# Waterloo Metro Quarter OSD Central Precinct (Building 2)

SSD-79307746

SSDA Response to Submissions

1 SECTION A - LEVEL 03 ROOF TERRACE
Scale: 1:50

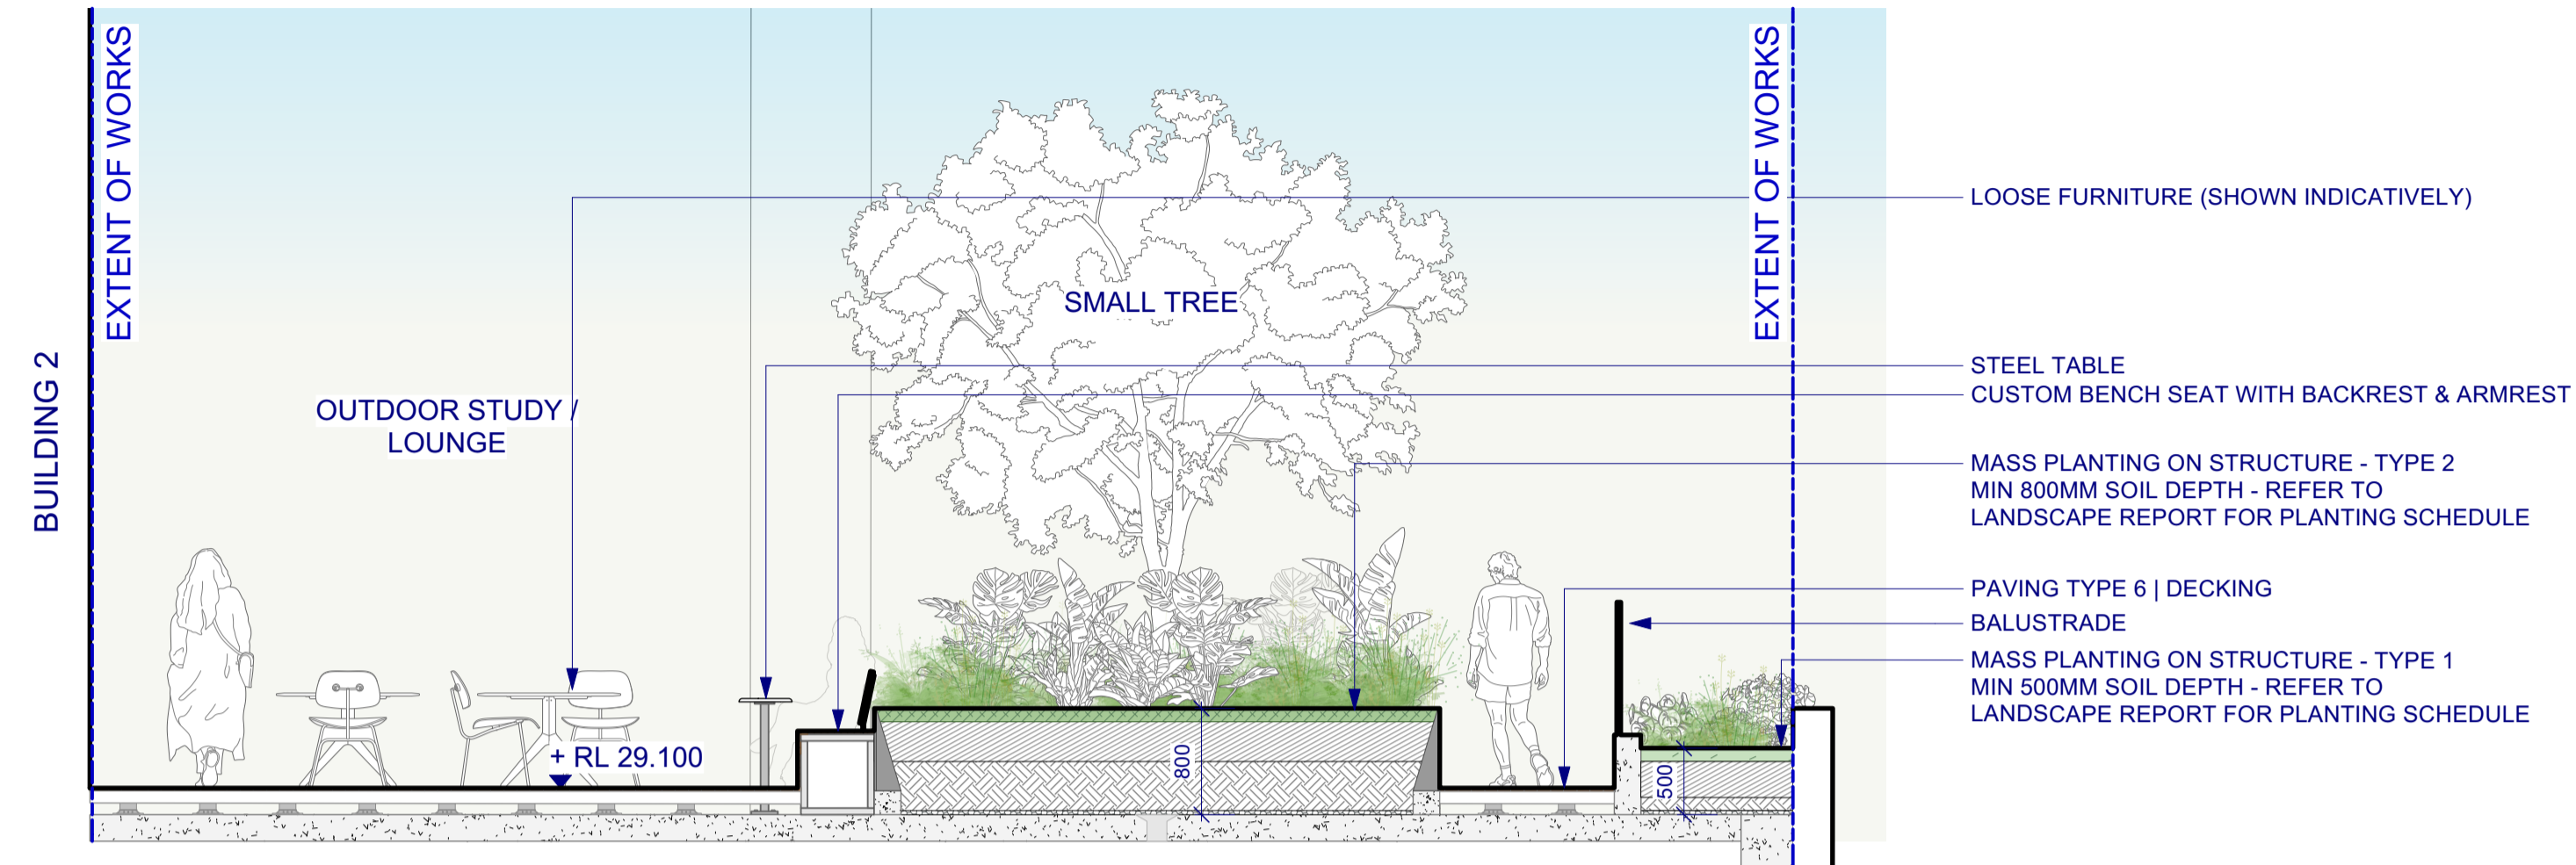
This must include how the proposed exclusions (such as the Level 1 and 2 Childcare outdoor play areas, and the Level 3 communal areas ) in the Central Precinct meet the definition of GFA under the Sydney Local Environmental Plan 2012 (Sydney LEP).

The level 3 outdoor terrace is excluded from GFA as the terrace is open to the sky and the balustrade height is below 1.4m from finish floor.
